Re: APS Professional Development Center (PDC) Parking Deck
3315 Louisiana Blvd., NE
Traffic Circulation Layout
Engineer's/Architect's Stamp **6-24-16** (G18-D048)

Based upon the information provided in your submittal received 6-29-16, the above referenced plan cannot be approved for Building Permit until the following comments are addressed:

UPPER LEVEL TRAFFIC CIRCULATION LAYOUT

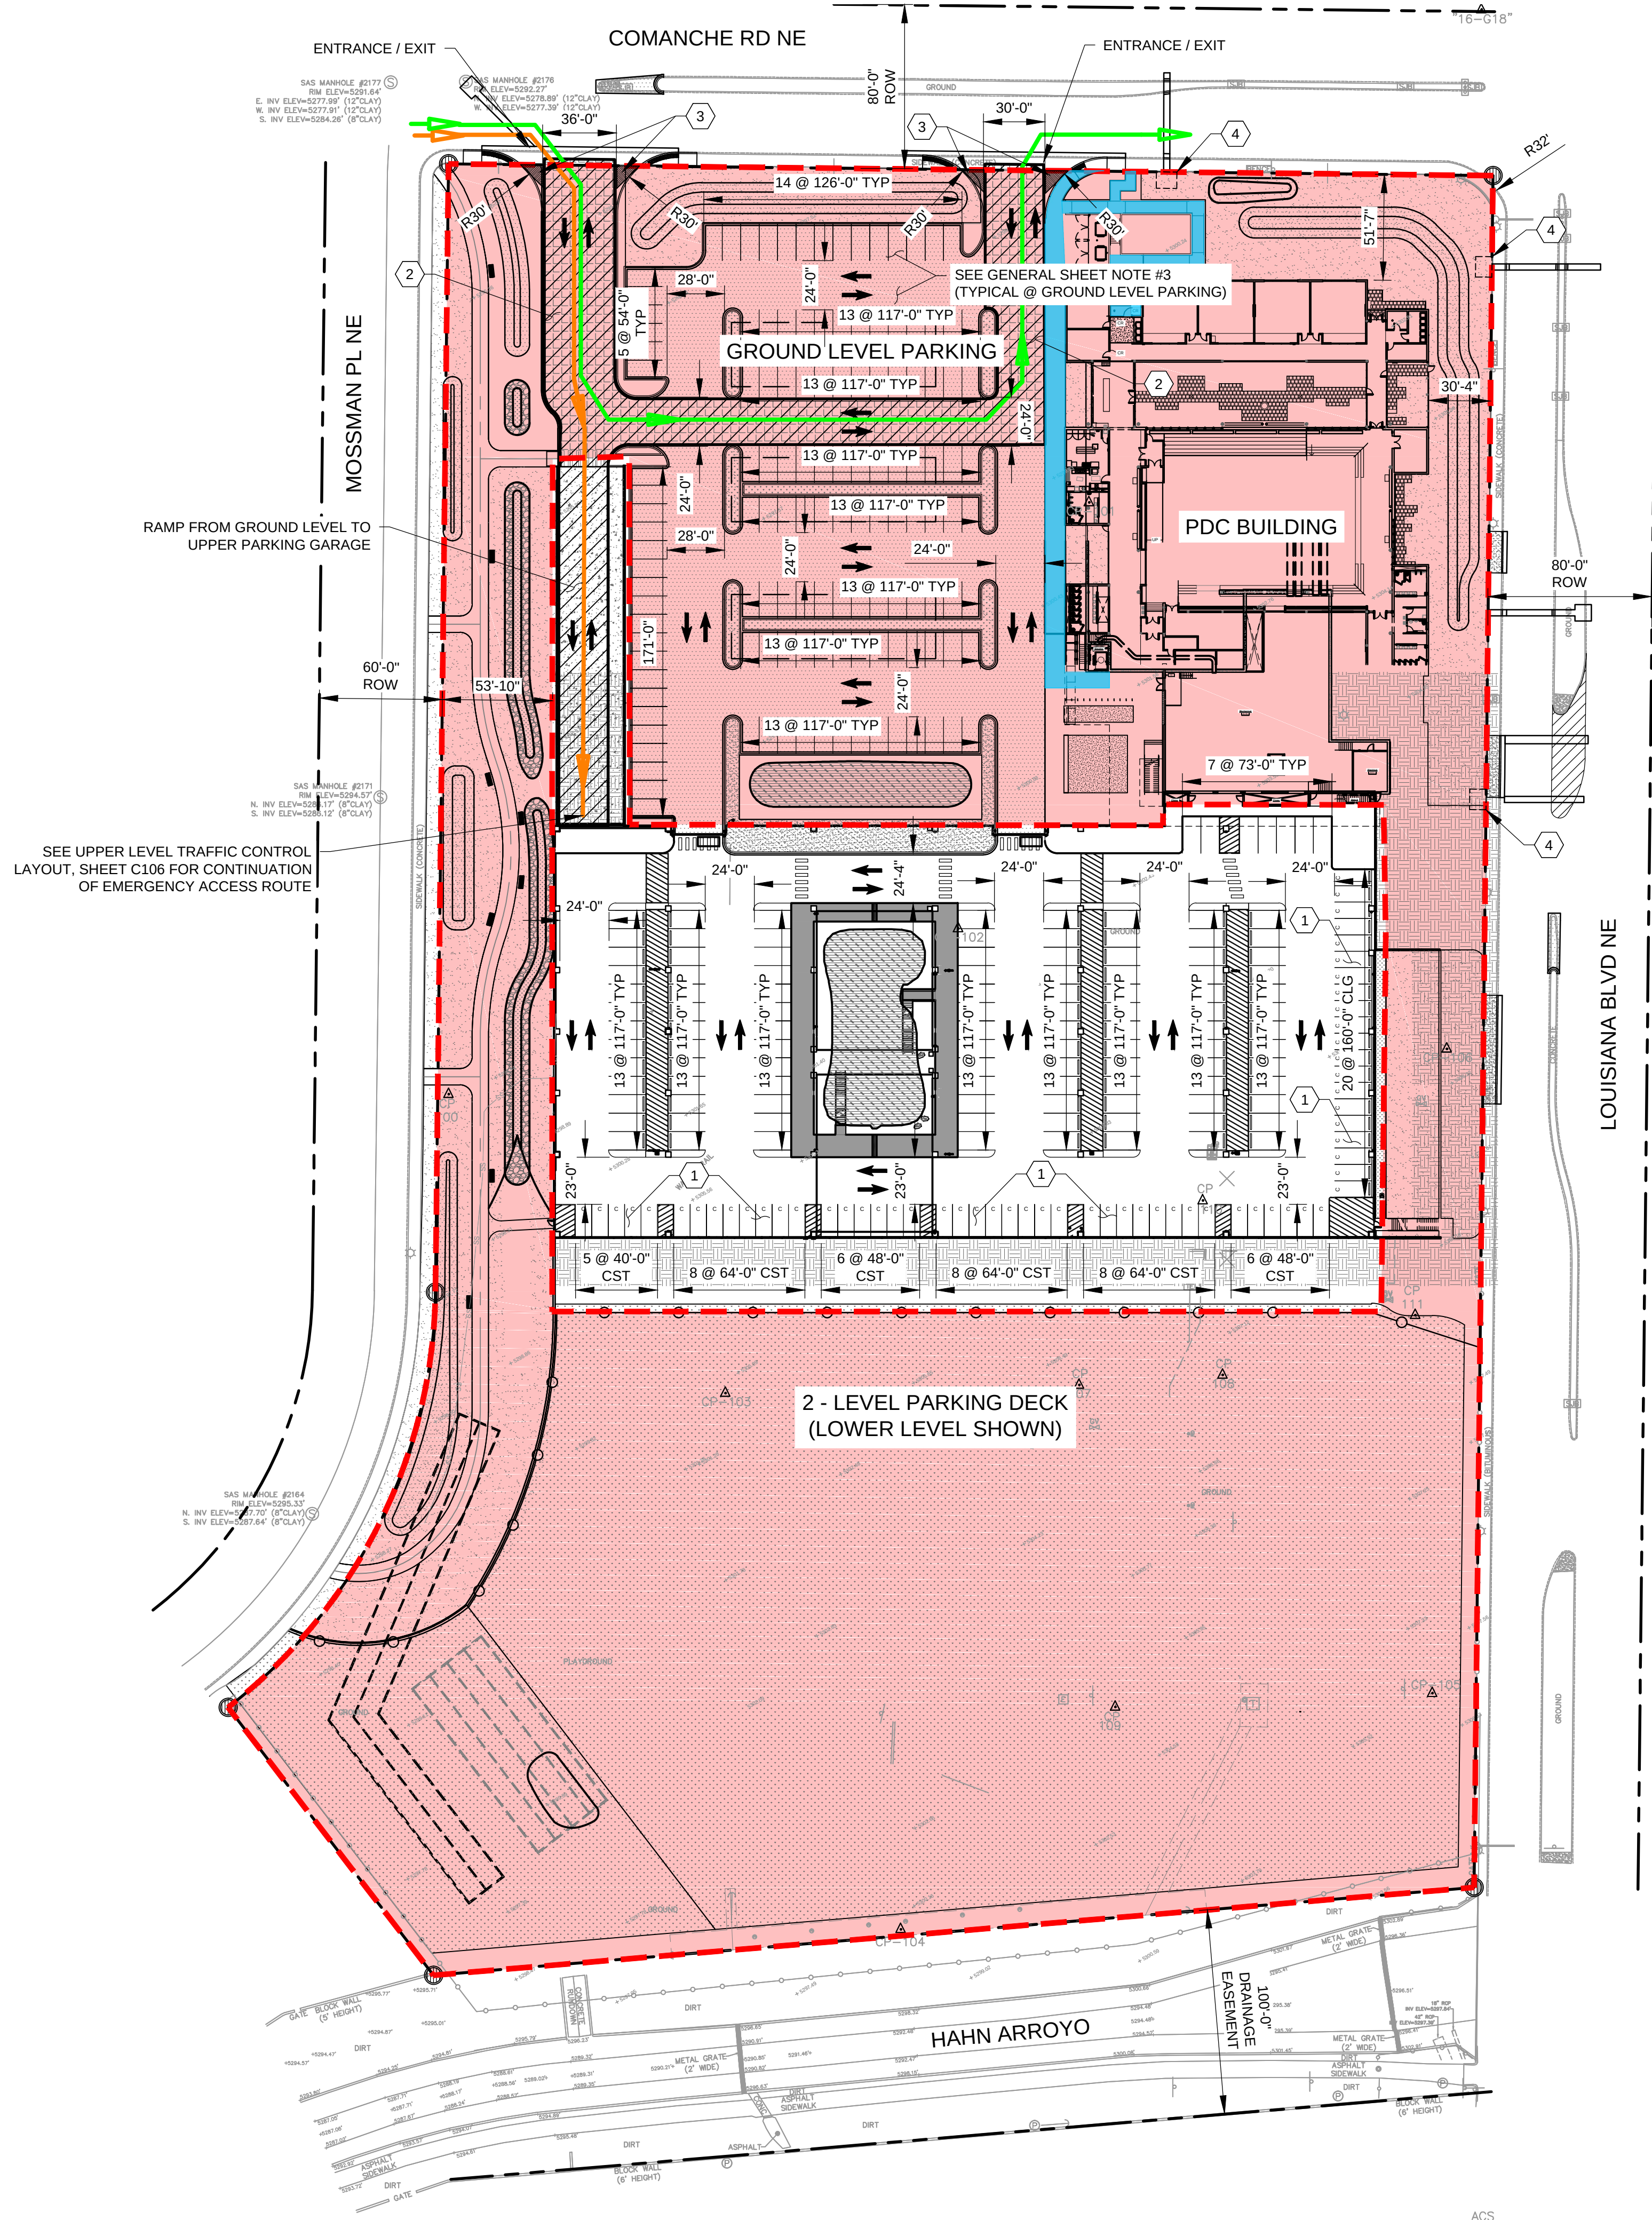
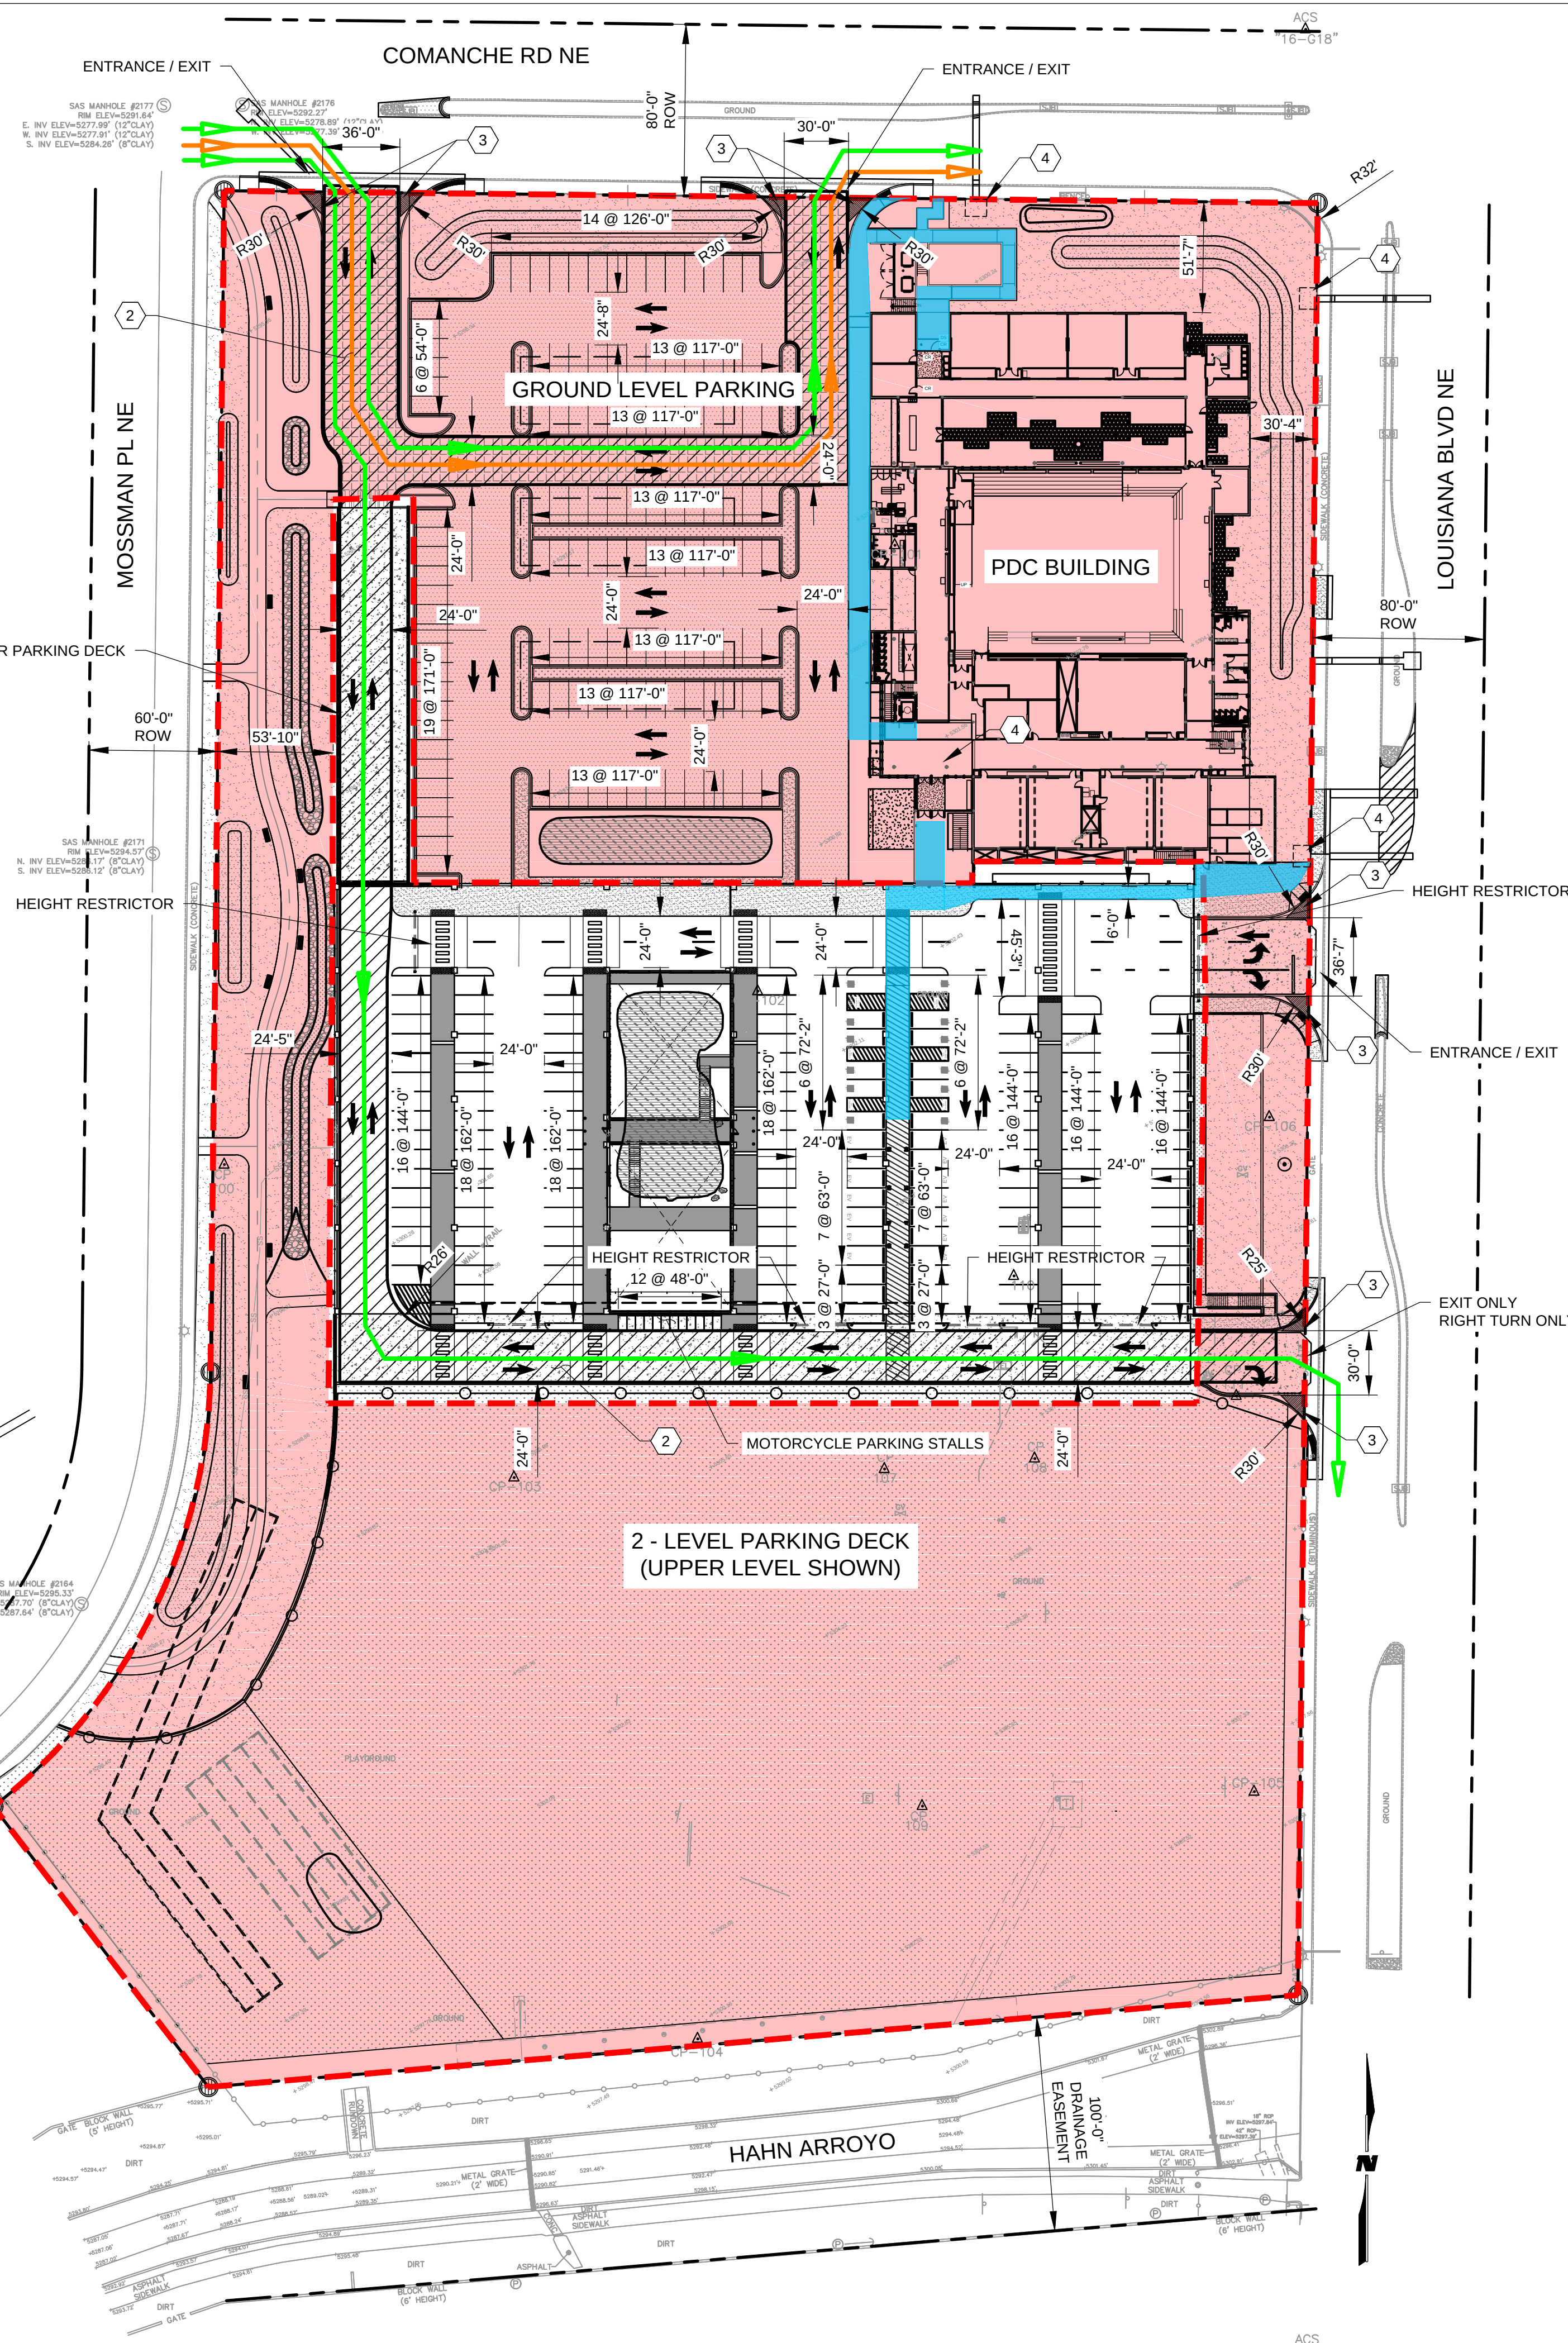
9. Label the compact parking spaces by placing the words "**COMPACT**" on the pavement of each space.
10. The handicap accessible spaces must be a minimum of 8.5 ft. in width.

11. The handicap accessible spaces must include an 8 ft. wide van access aisle; all other aisles should be 5 ft. in width.
12. The ADA accessible parking sign must have the required language per 66-7-352.4C NMSA 1978 **"Violators Are Subject to a Fine and/or Towing."** Please call out detail and location of HC signs. Please show a detail of signage.

13. The ADA access aisles shall have the words **"NO PARKING"** in capital letters, each of which shall be at least one foot high and at least two inches wide, placed at the rear of the parking space so as to be close to where an adjacent vehicle's rear tire would be placed. (66-1-4.1.B NMSA 1978)

16. Per DPM, a 6 ft. wide ADA accessible pedestrian pathway is required from the HC parking stall access aisles to the building entrances. Please clearly show this pathway and provide details. Please detail location of future HC spaces and ADA access isles.
